KIRKLEES METROPOLITAN COUNCIL INVESTMENT & REGENERATION SERVICE

DELEGATED DECISION TO DETERMINE PLANNING APPLICATIONS

Reference No:	2024/62/90282/W
Site Address:	16, Pembroke Court, Crosland Moor, Huddersfield, HD4 5NB
Description:	Alterations to roof and erection of front and rear dormers
Recommending Officer:	Joanna Rednall

HOUSEHOLDER DELEGATED REPORT

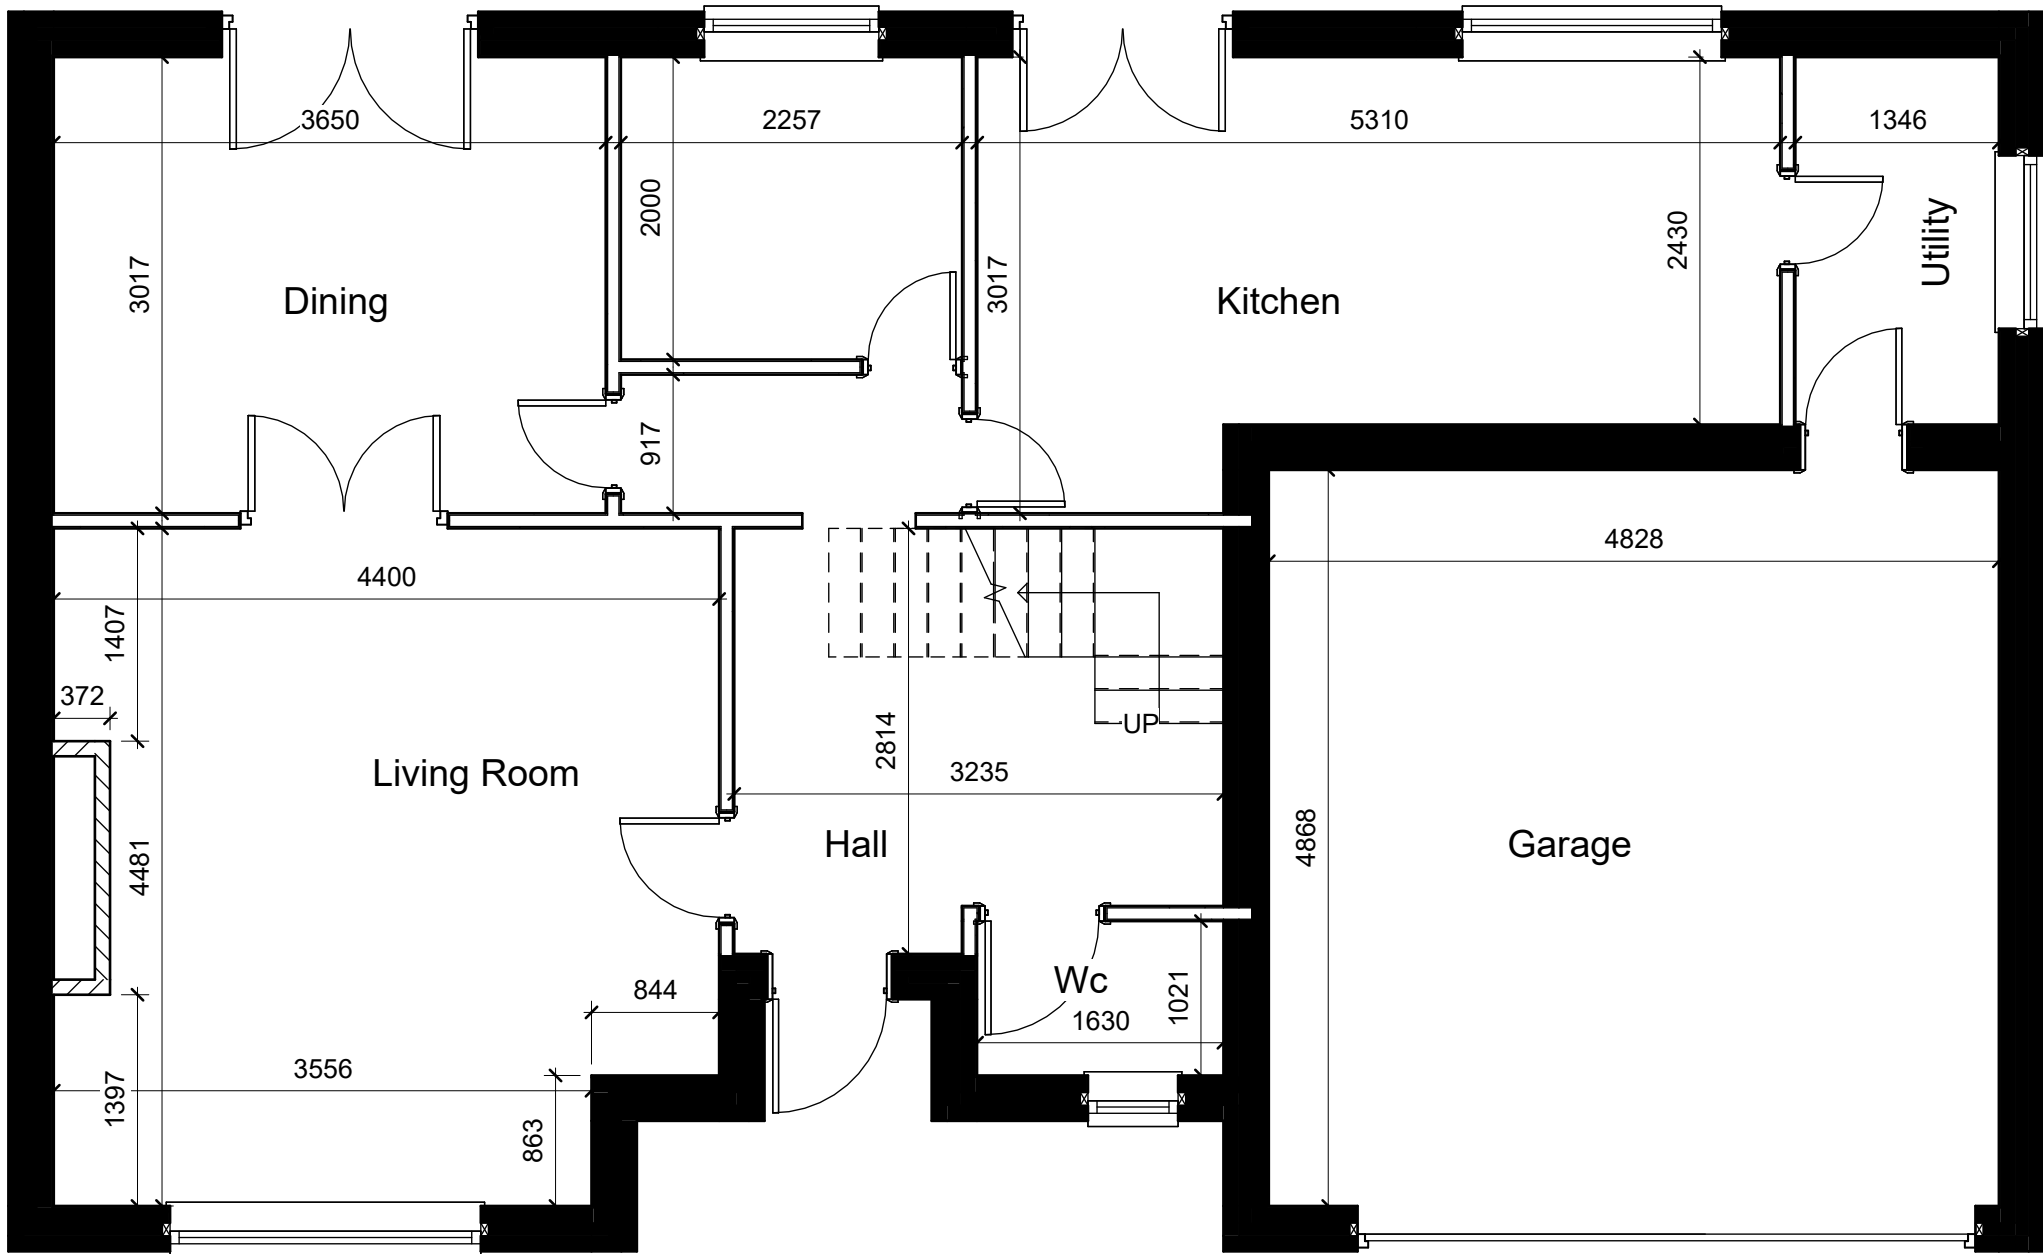
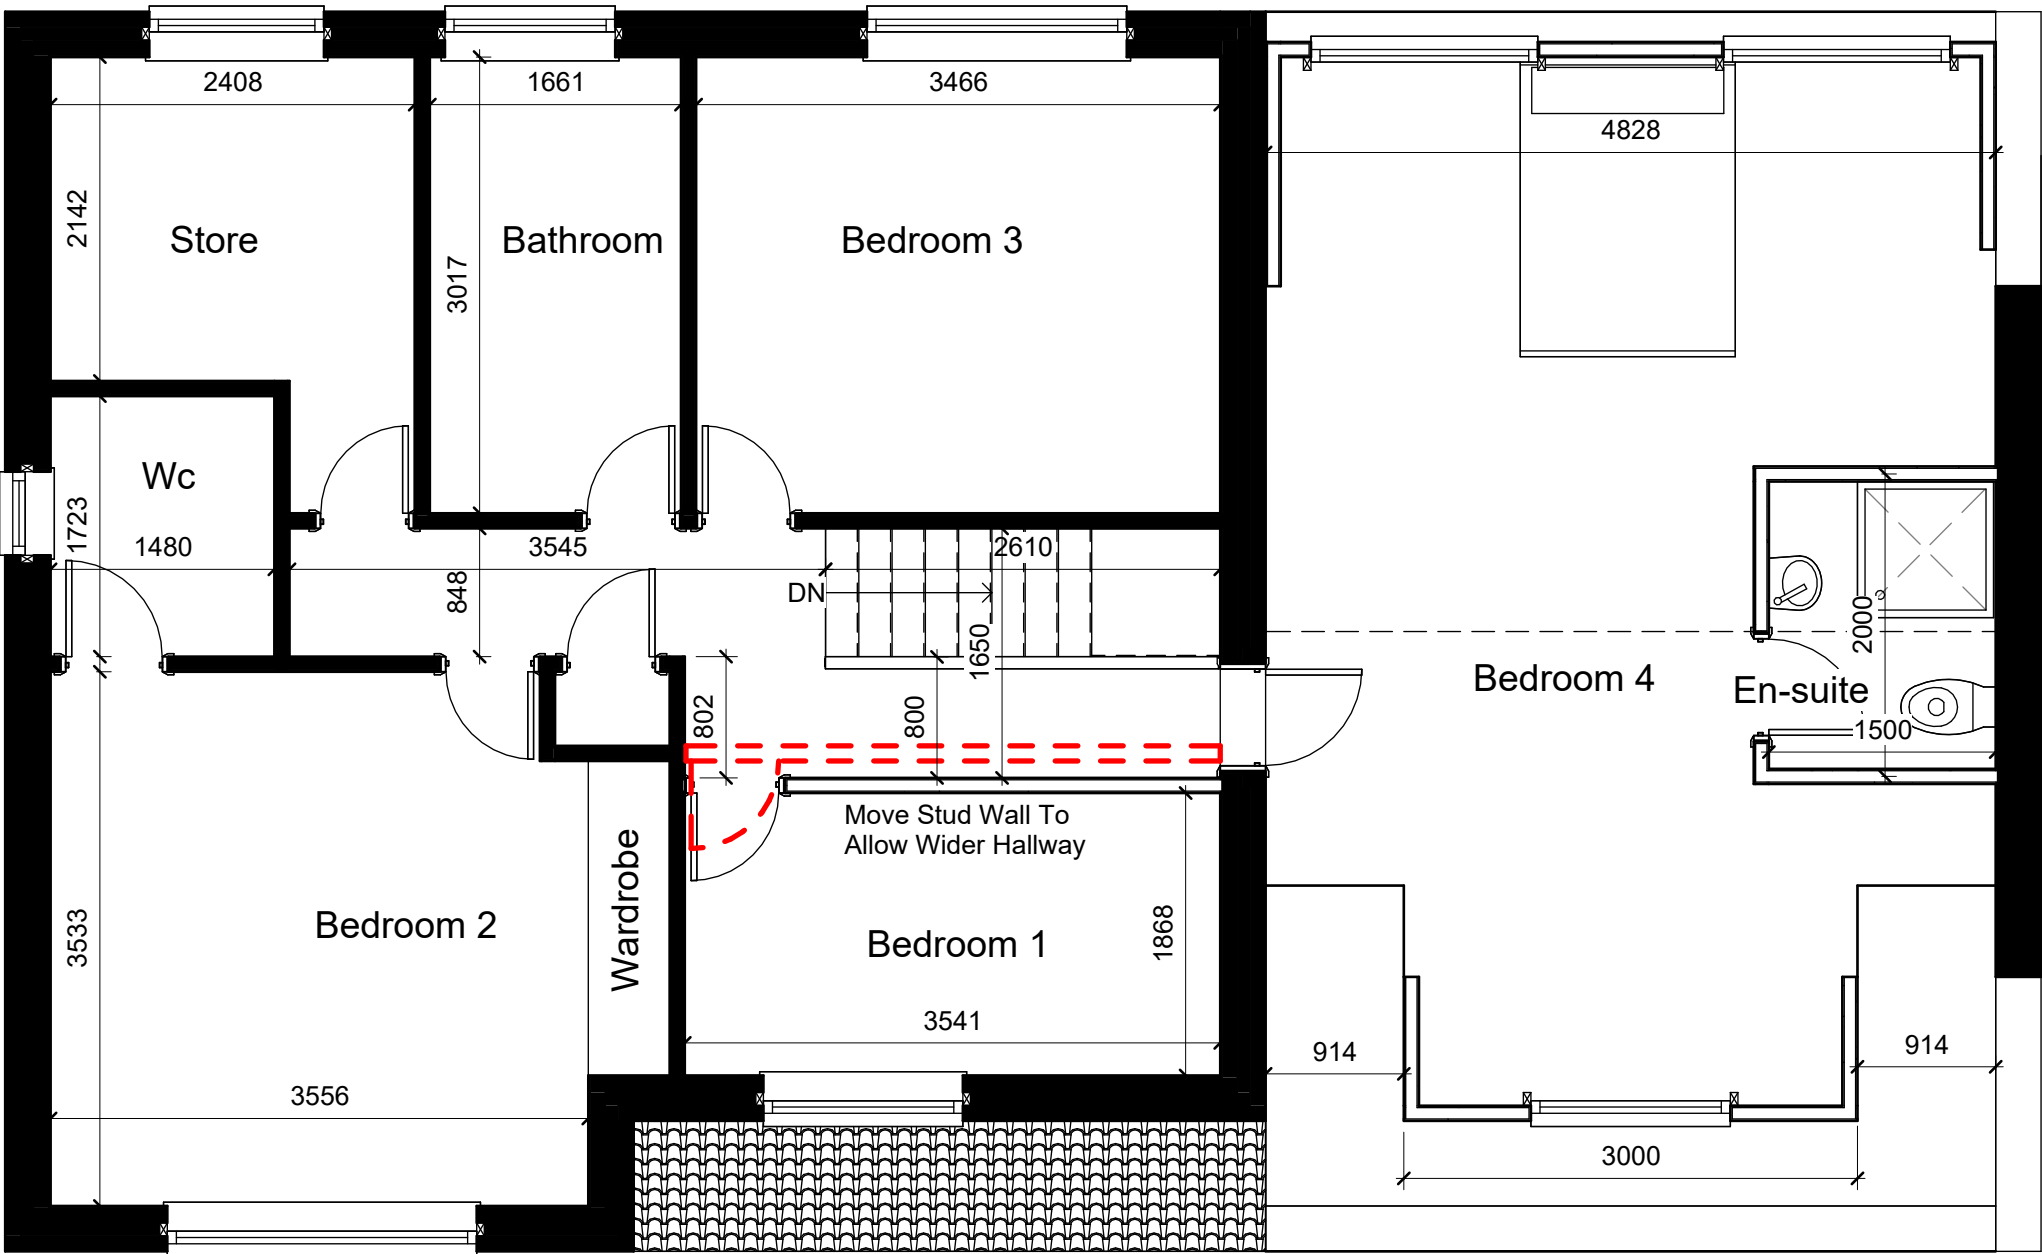
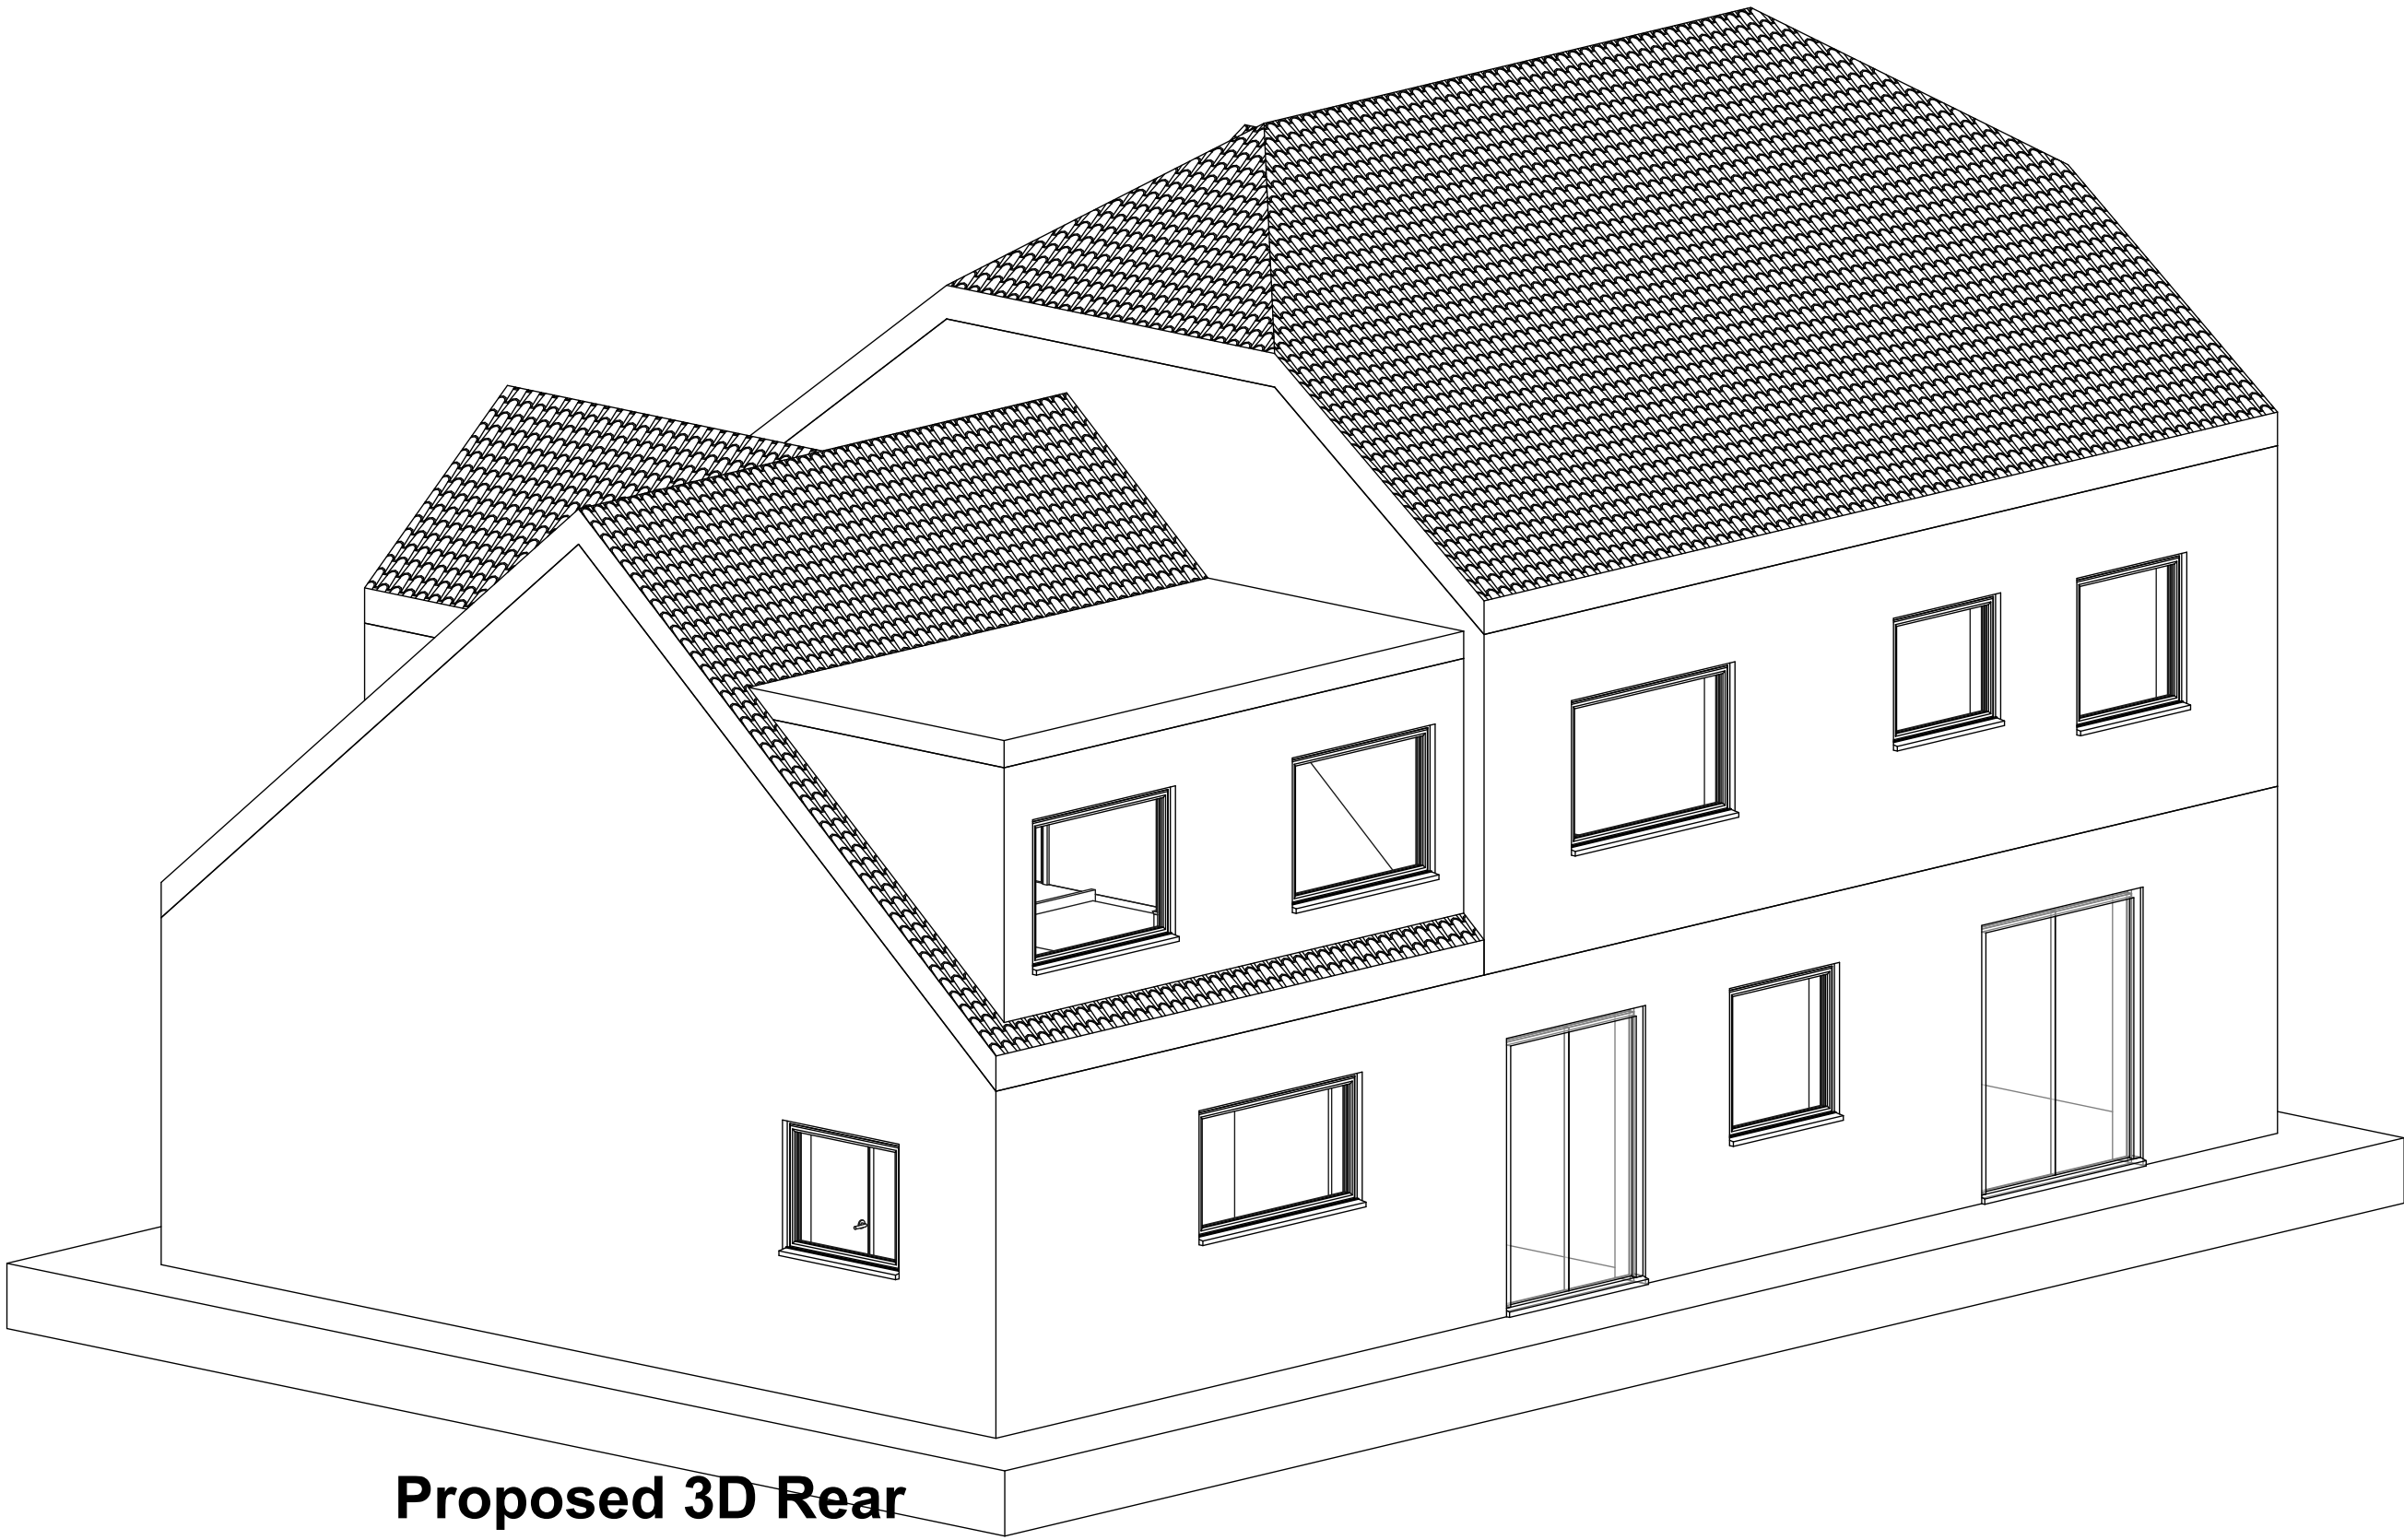
Permission is sought for alterations to roof (changing half hip to full gable) and erection of front and rear dormer.

The roof form is altered from Jerkinhead to Gable as part of the works.
